From: Simon Davis <Simon.Davis@arun.gov.uk>
Sent: 26 November 2020 12:24
To: Daniel OShea
Subject: RE: Open Space to south of Summer Lane

I have a resident asking me why you are moving earth from the north side of Summer Lane onto the open space area to the south. The resident alleges that a bank is being created near the boundary with existing houses (I believe this to be on the eastern side of the open space). Can you advise what is going on please?

Figure 3b – Public Open Space Landscape Strategy (from IJLA, 2019)

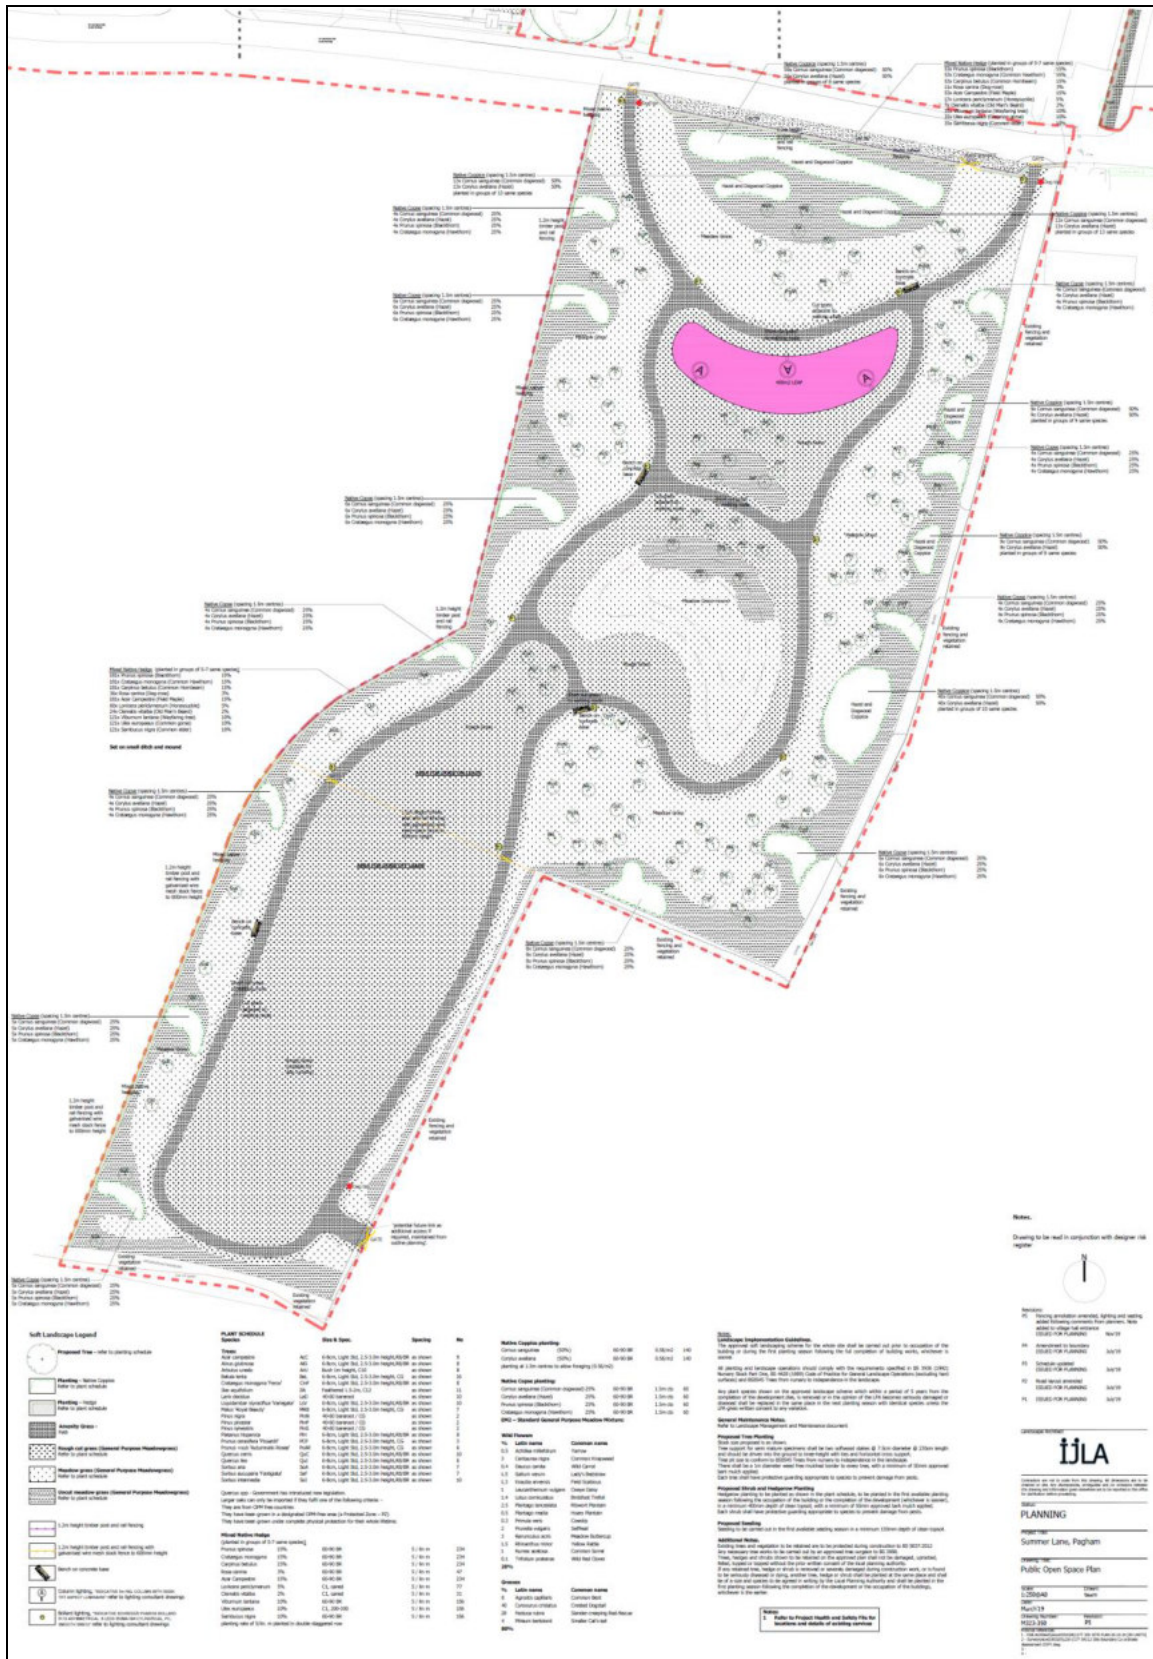
I'm sorry, I couldn't see the mound when I first looked at the plan but I can now see it. However, can you advise how high this will be as there is no detail on that aspect.

No problem, it's not exactly obvious amongst the other hatching, but the proposal is that the contours would be approx. 1m intervals and they are drawn at 3m offsets so that it would be a comfortable 1:3 slope. Therefore with the bottom contour being at the ground level the 3rd contour could be at circa 2m height and then crowned.

Around the edges, the hedges are raised on small engineered banks/shallow ditches, to provide microhabitats in accordance with the Ecological Mitigation Strategy.

Within the approved POS plan there is a grass mound to be formed in the middle of the site, along with bunding around the edges. The earth has therefore been removed from the north to level the site and enable the excess to be utilised in forming the raised elements to the south.
